DRB Application No.: 05DRB-00205 (SBP)  
Project Name: ALAMEDA BUSINESS PARK  
Agent: Sanders Associates Architects

February 11, 2005

**CITY OF ALBUQUERQUE  
PLANNING DEPARTMENT  
February 16, 2004  
DRB Comments**

**RE: Lot 42, Alameda Business Park/SPBP**

**1 NORTH ELEVATION**  
SCALE: 1/8" = 1'-0"

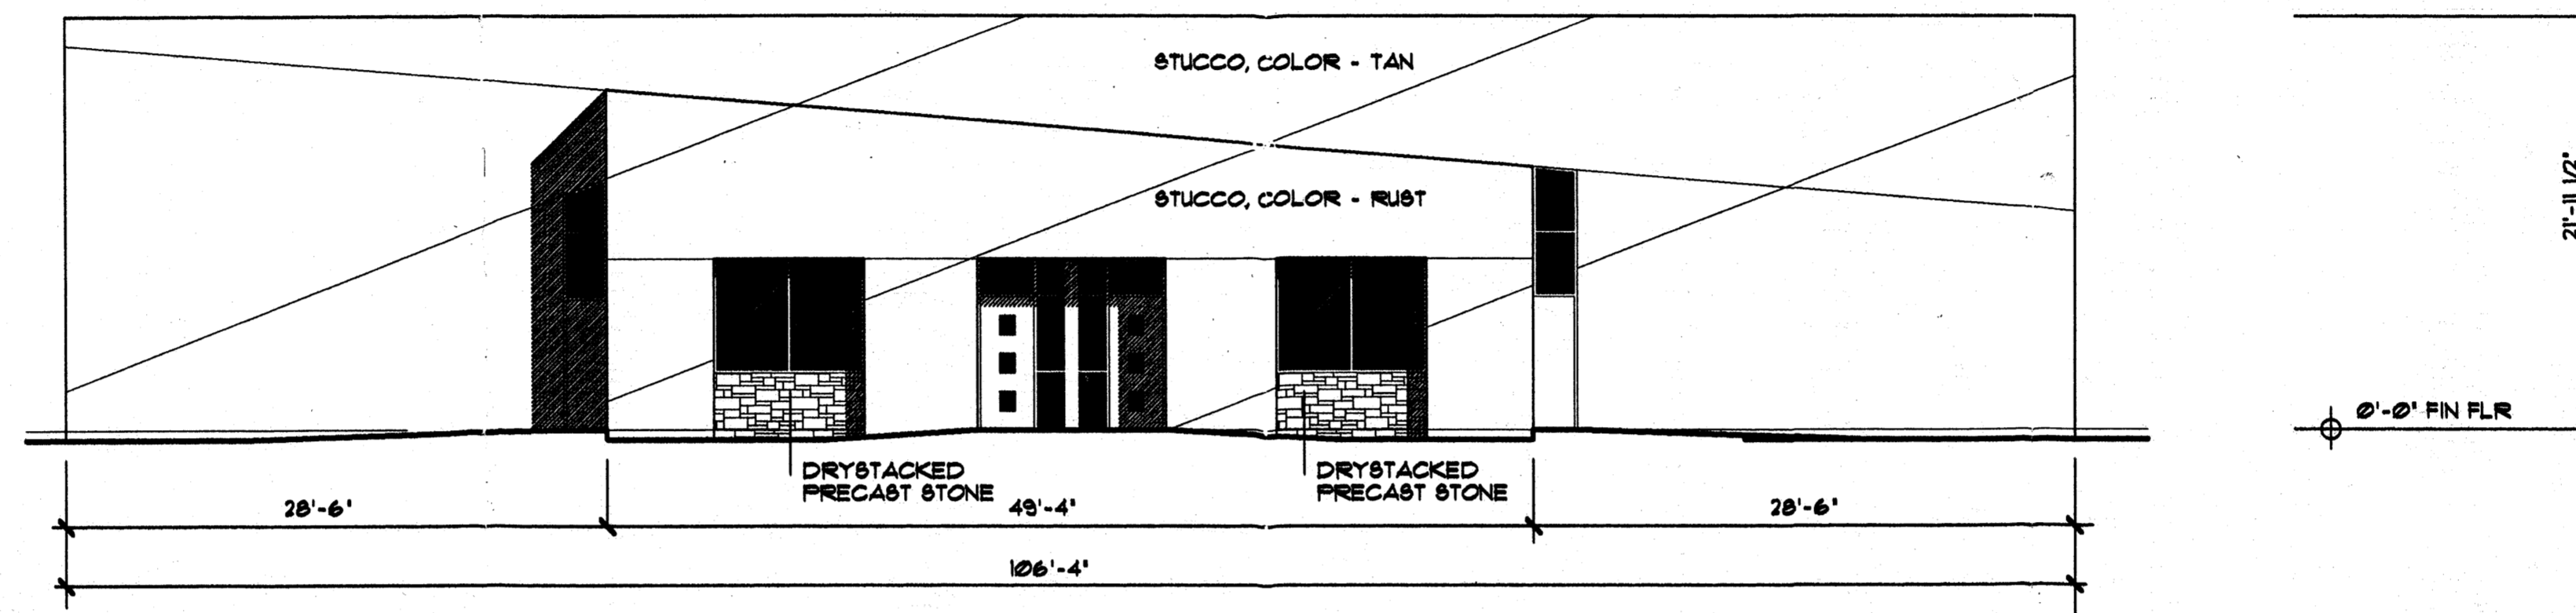
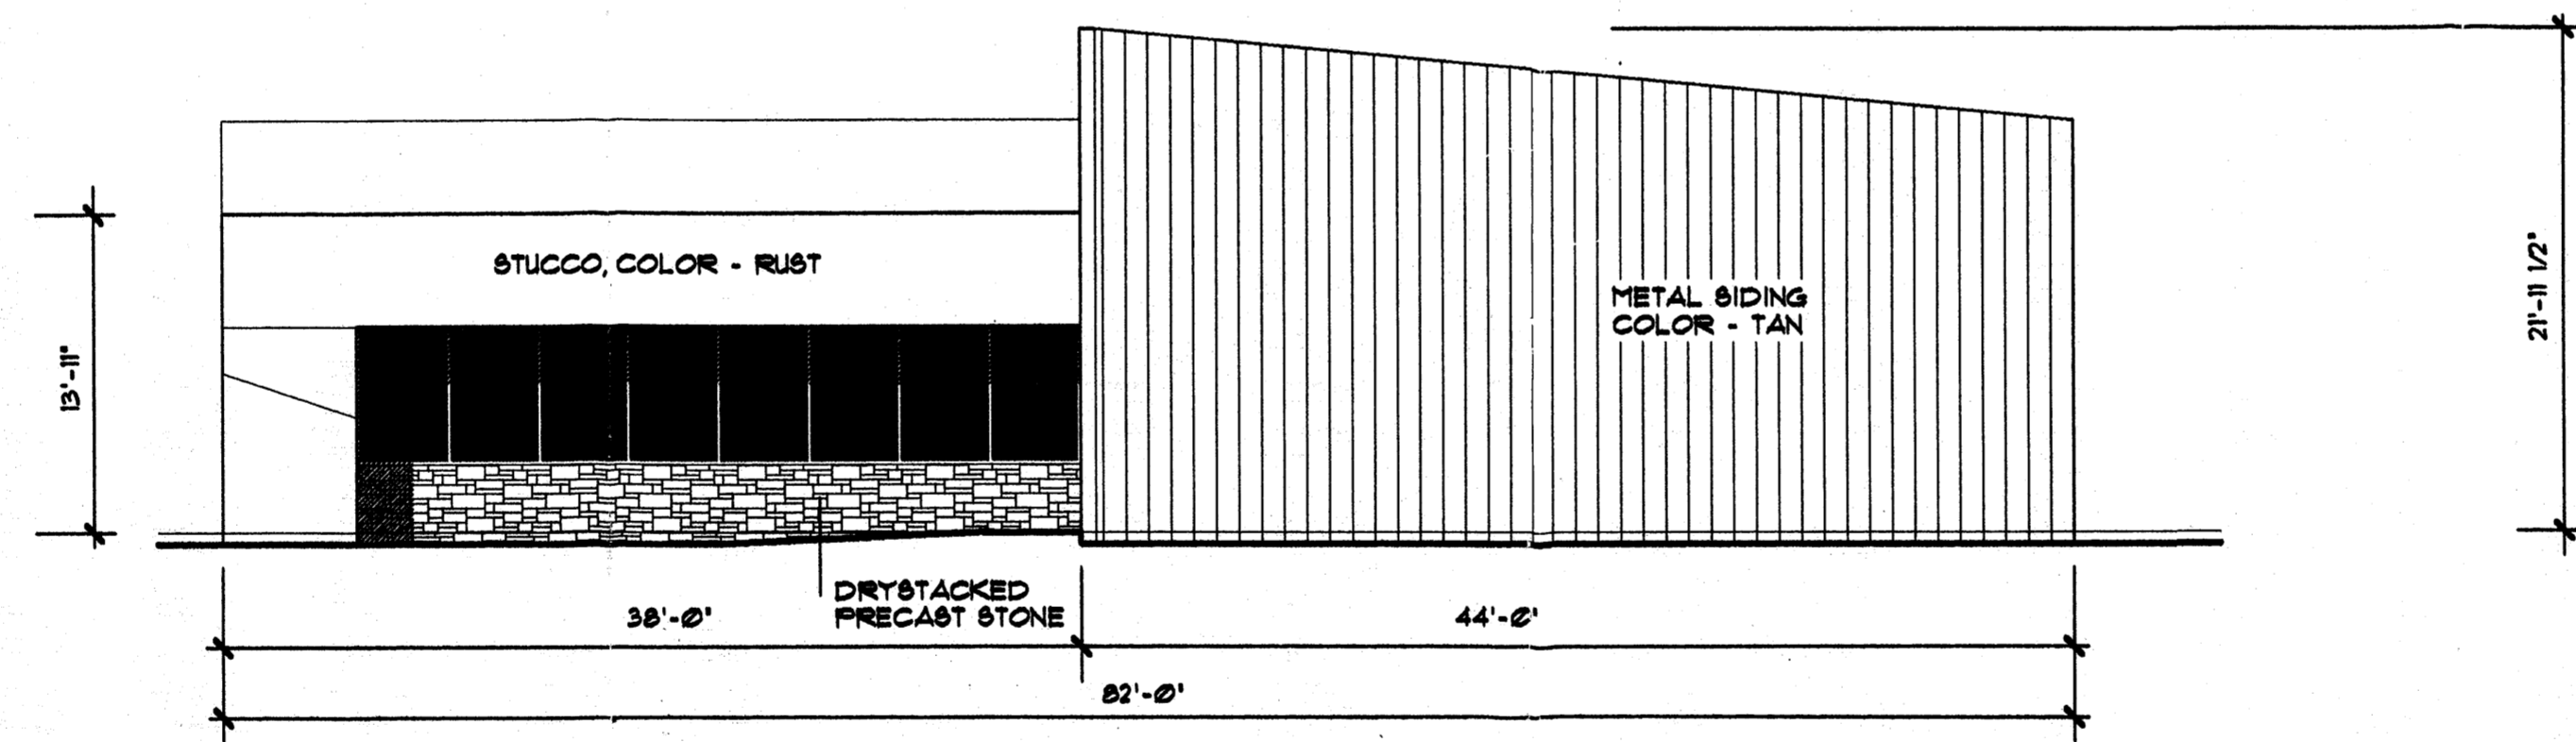
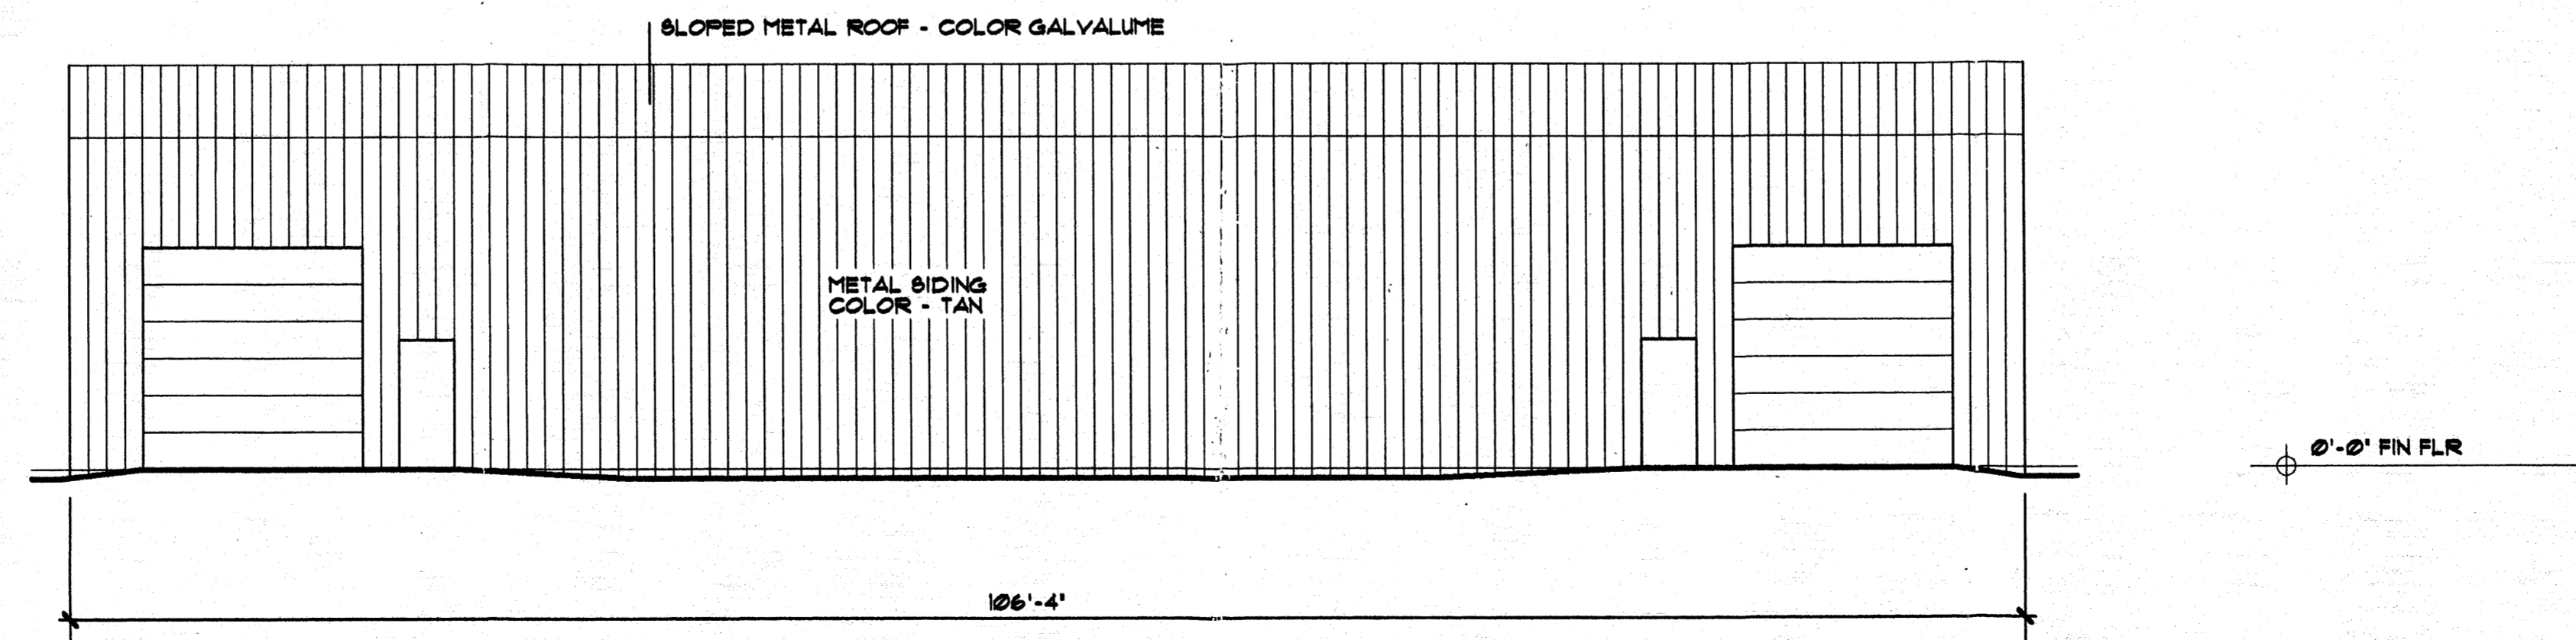
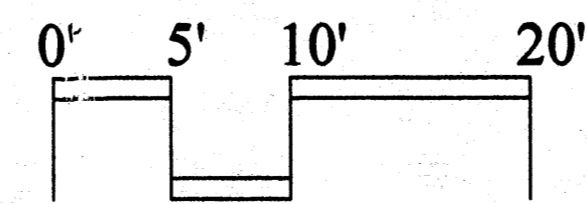
5. Roofs may be either flat or pitched. Flat roofs shall have a perimeter parapet which at no point will be lower than any portion of the roof it surrounds. Pitched roofs are to be of either concrete tiles, clay tiles or pre-finished ribbed metal. Tile and metal roof colors are to be consistent with the building colors are not to have a highly reflective surface.

6. Roof Equipment Screens
  - A. Mechanical equipment on roofs is to be screened from public view as much as practical. Roof equipment screens are to be at least as high as the highest part of the equipment. Roof screens are to be architecturally compatible with the building.

The roof for the office has a parapet which shields view of both the roof and all mechanical equipment. The warehouse portion has a pre-finished ribbed metal roof which shall not have a highly reflective surface per requirements of the Alameda Business Park Master Plan.
